Burbage Parish Council

Written Representation Summary

Map 4.9: Option 7 – Hinckley / Burbage

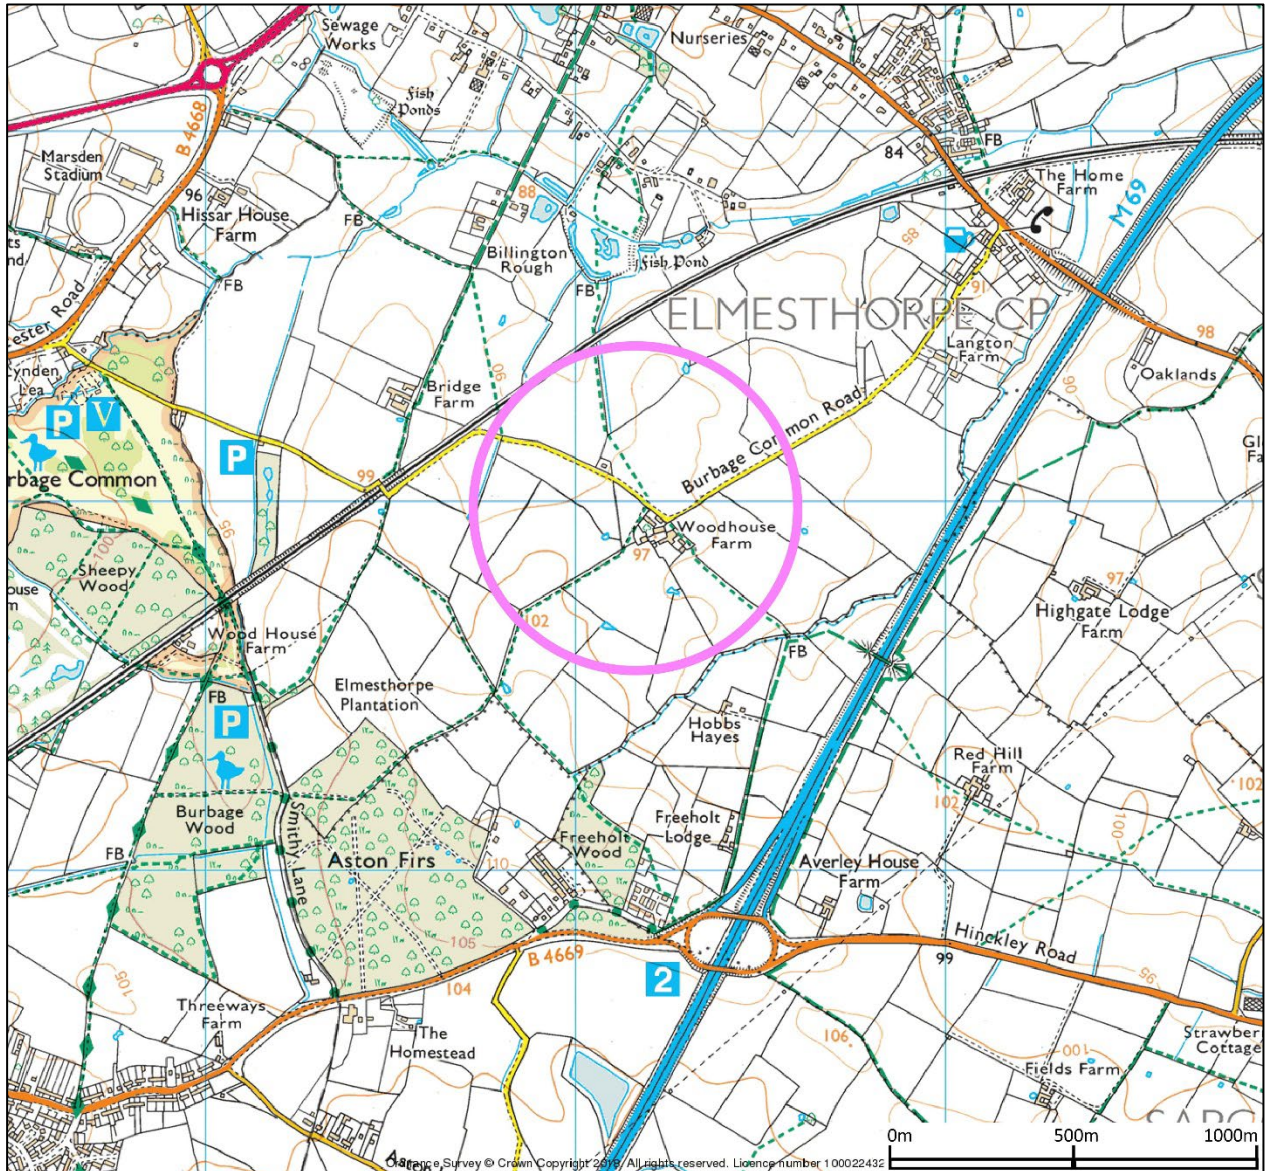
Assessment (APP113) of the site does not include the amenity value of Burbage Common and Woods. In the Ecology paragraph (4.117) we consider the distance of 600m to the SSSI is misleading.
